CITY OF ALBUQUERQUE

March 22, 2021

**RE: Lot 9 Block 1 Volcano Cliffs Unit 22 SAD 228
8005 Alto Rey Ct. NW
Grading and Drainage Plan
Engineers Stamp Date: 10/19/2020 (D10D003N9)
CO Certification Date: 3/11/2021**

SHEET TITLE:
GRADING AND
DRAINAGE PLAN

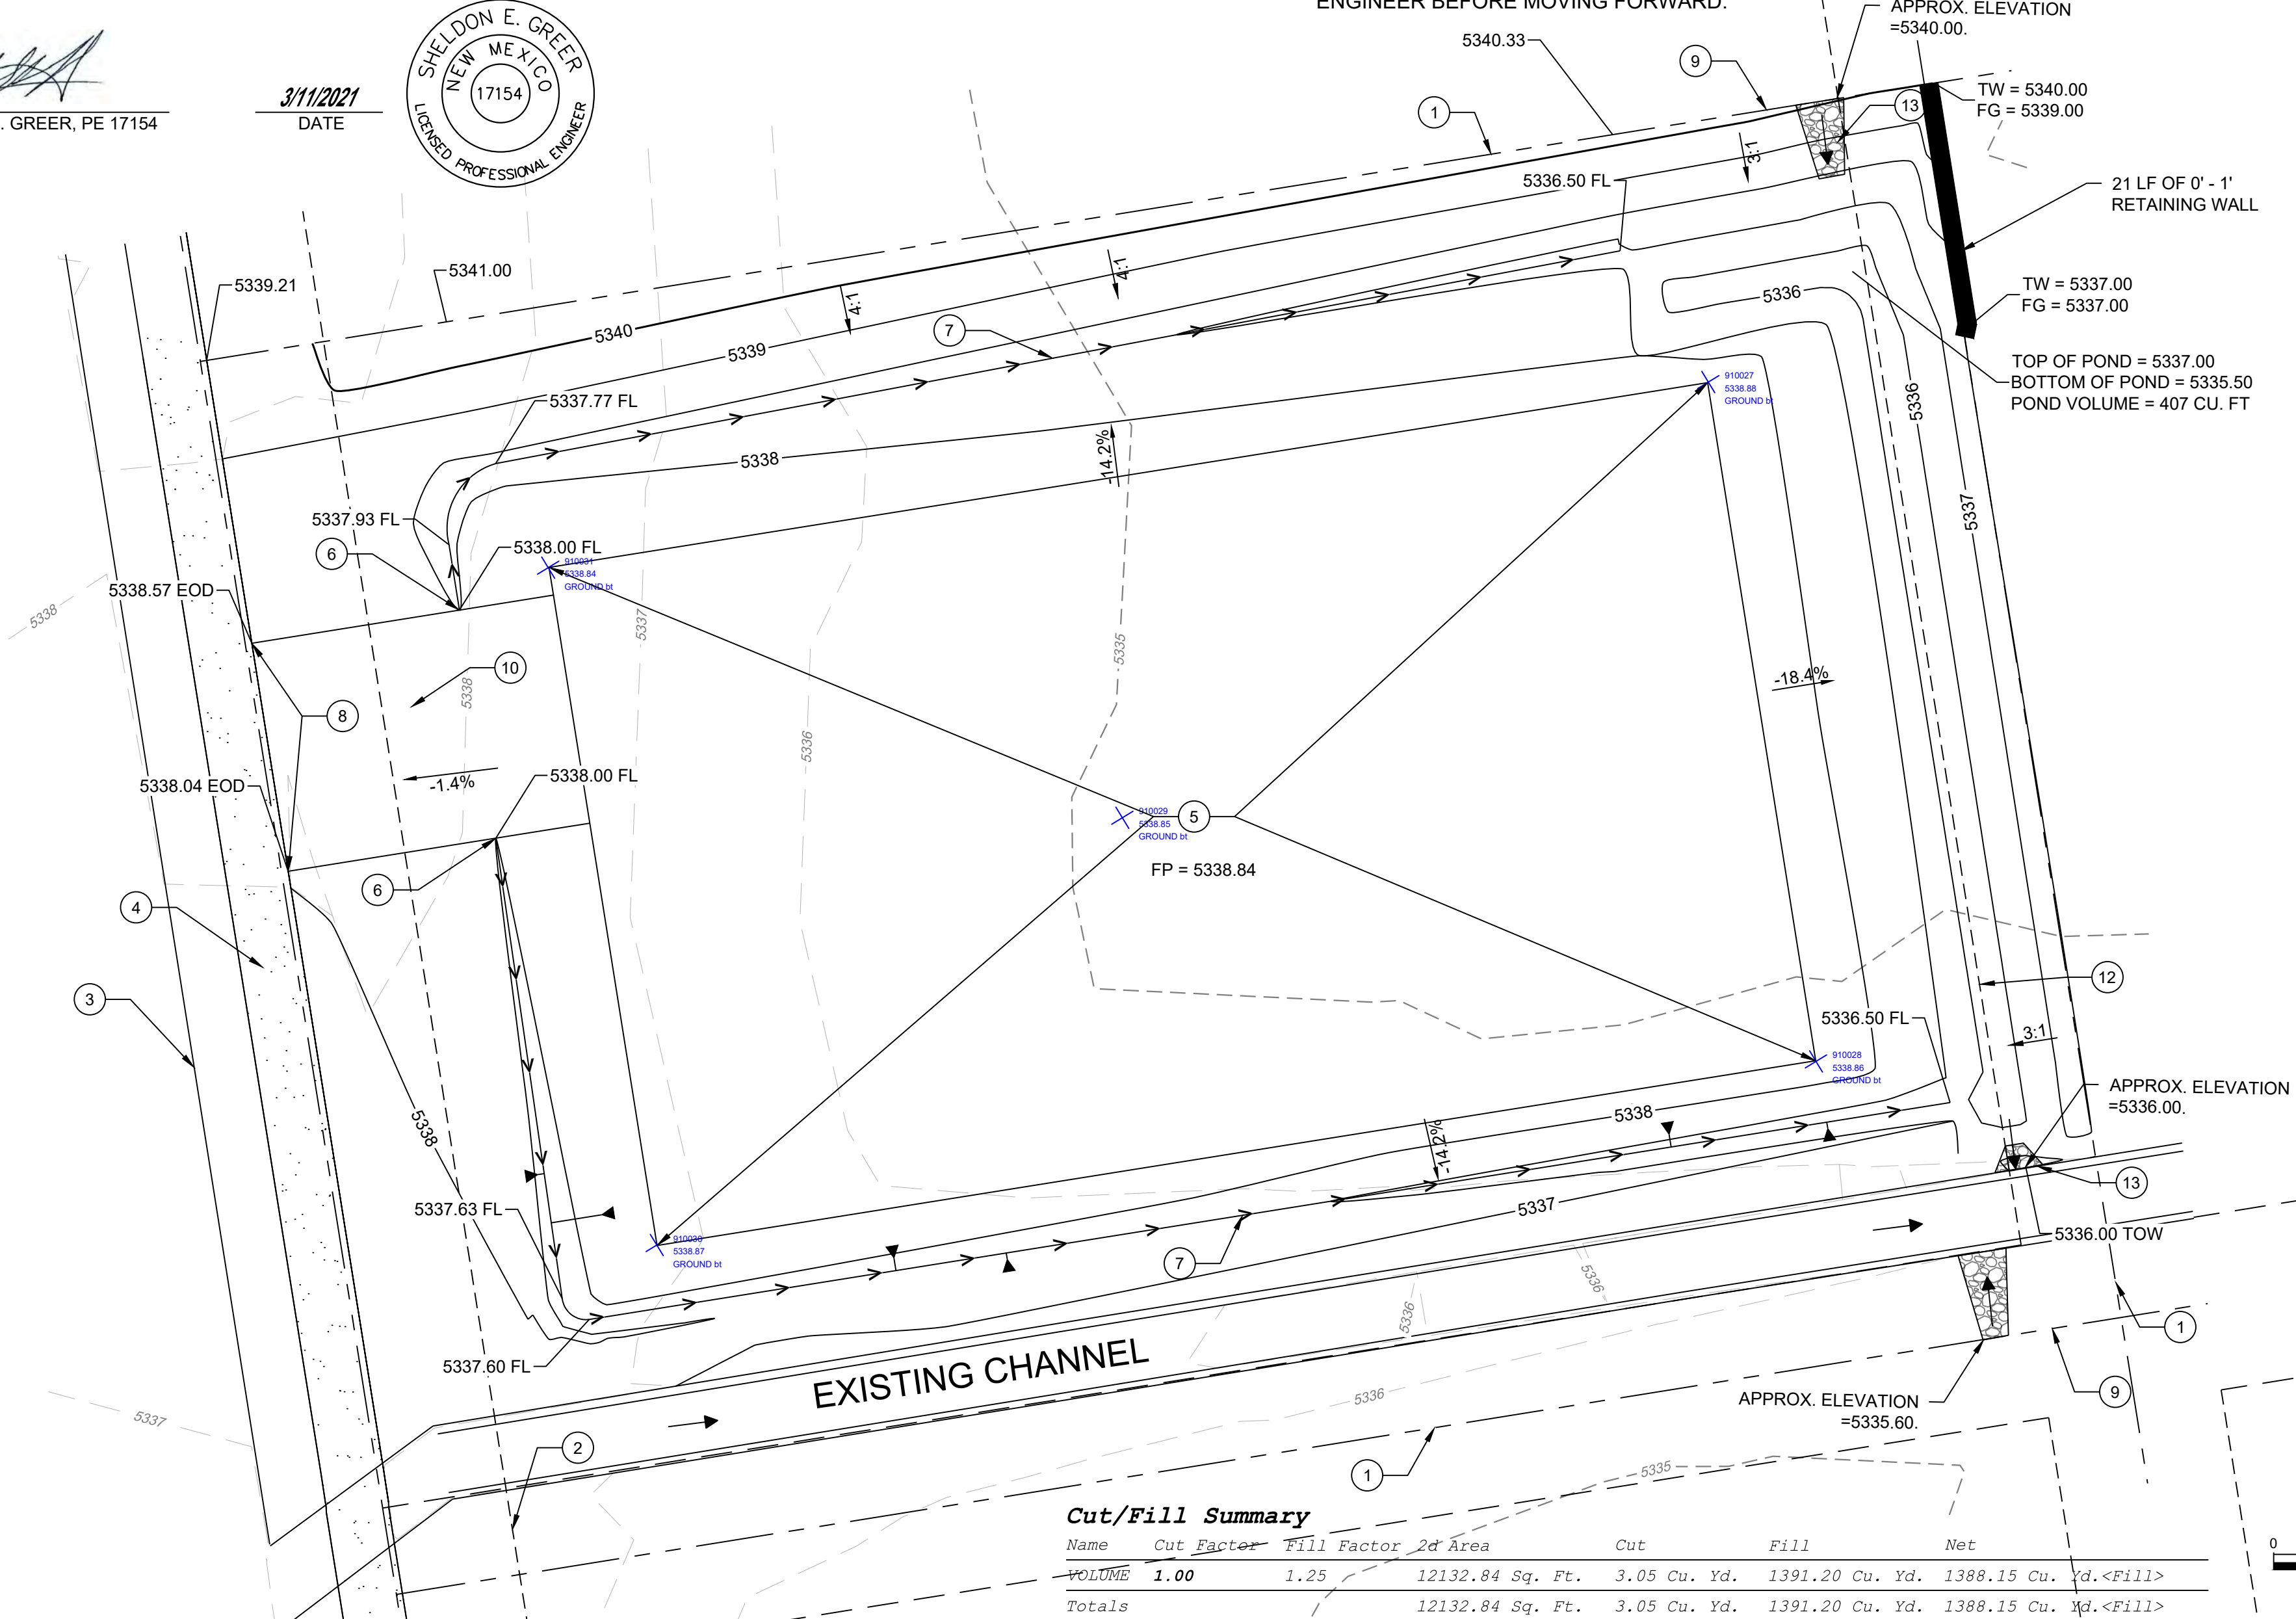
- Lot did not have an address, provide address
- Have all dirt ramps removed from the streets. Crusher fines or lumber are to be used for driving over a curb.
